**MECKLENBURG COUNTY**  
**Land Use & Environmental Services Agency**

**MEMORANDUM**

Subject: Rezoning Petition Comments

**2023-002: 2101 McKee Rd**

RZ-1

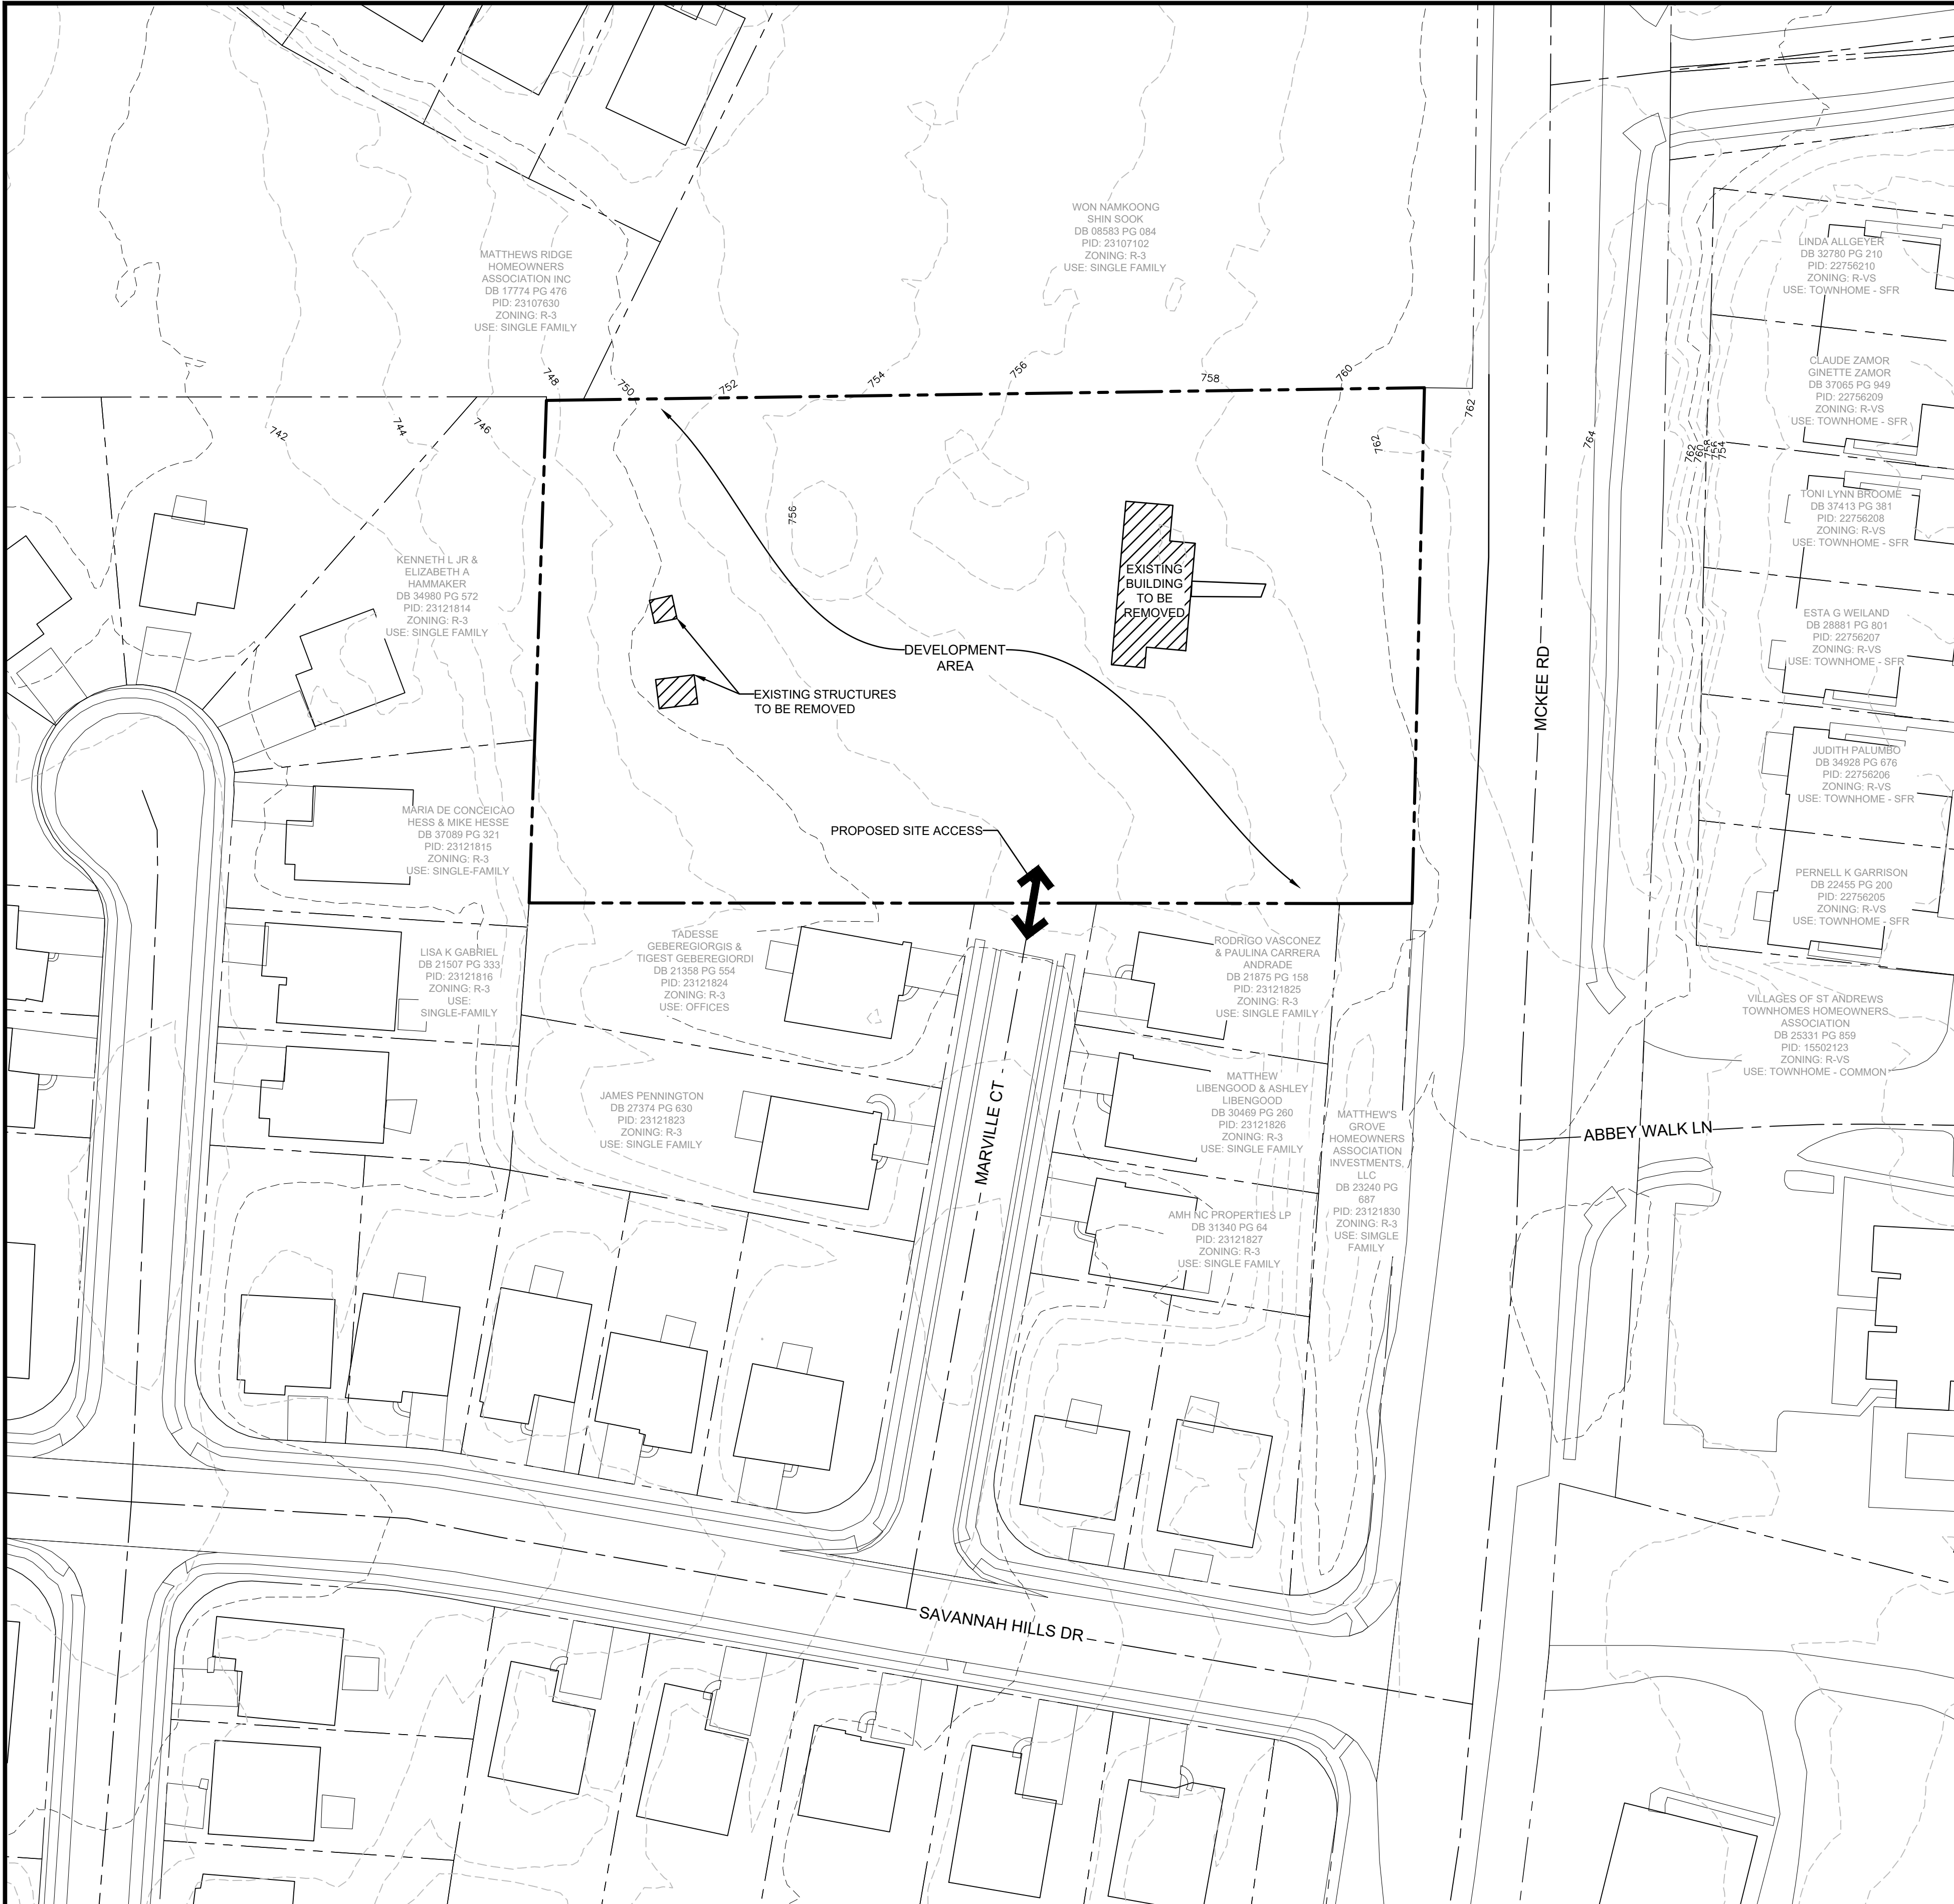
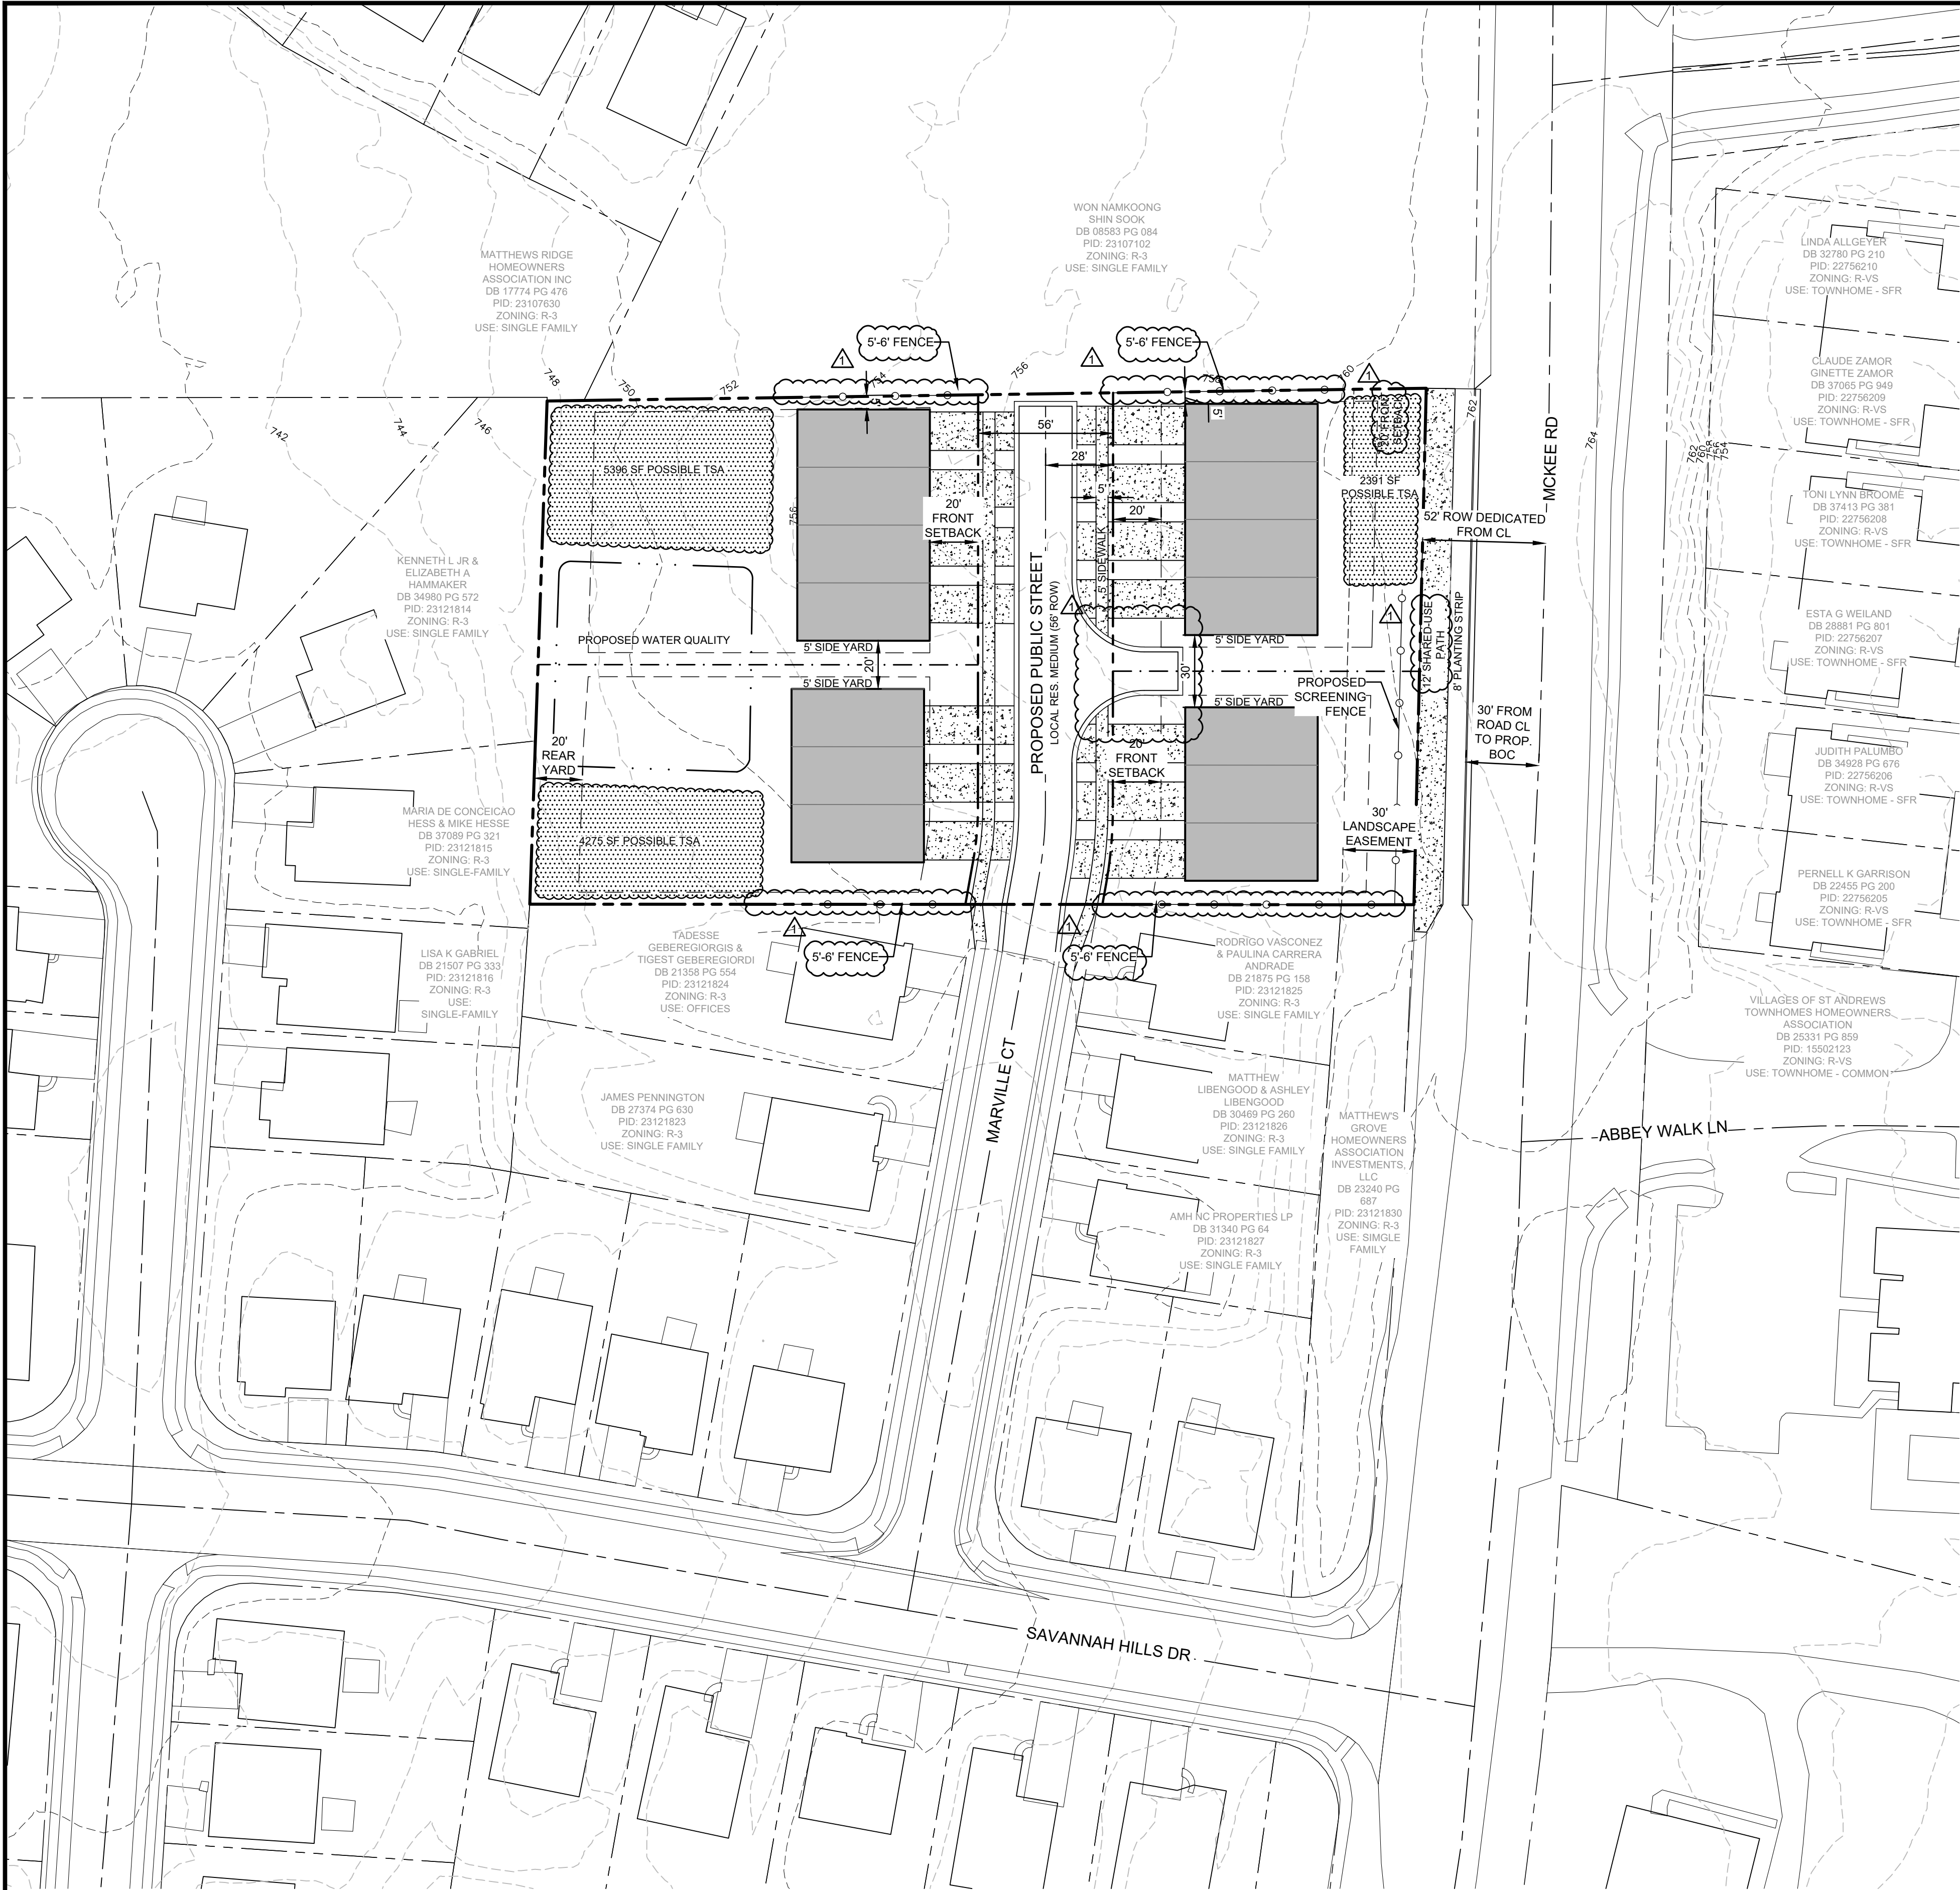
*Ground Water Services Comments:* Groundwater & Wastewater Services records indicate a registered

septic system exists on parcel 231-071-20. No regulations govern the abandonment of septic systems; however, GWS does recommend that septic tanks be pumped by a NC Licensed Septic Hauler to remove any residual contents and then crushed and backfilled. This recommendation is made because improperly abandoned septic tanks may not be able to support the weight of vehicular traffic, structural foundations or people posing a safety hazard.
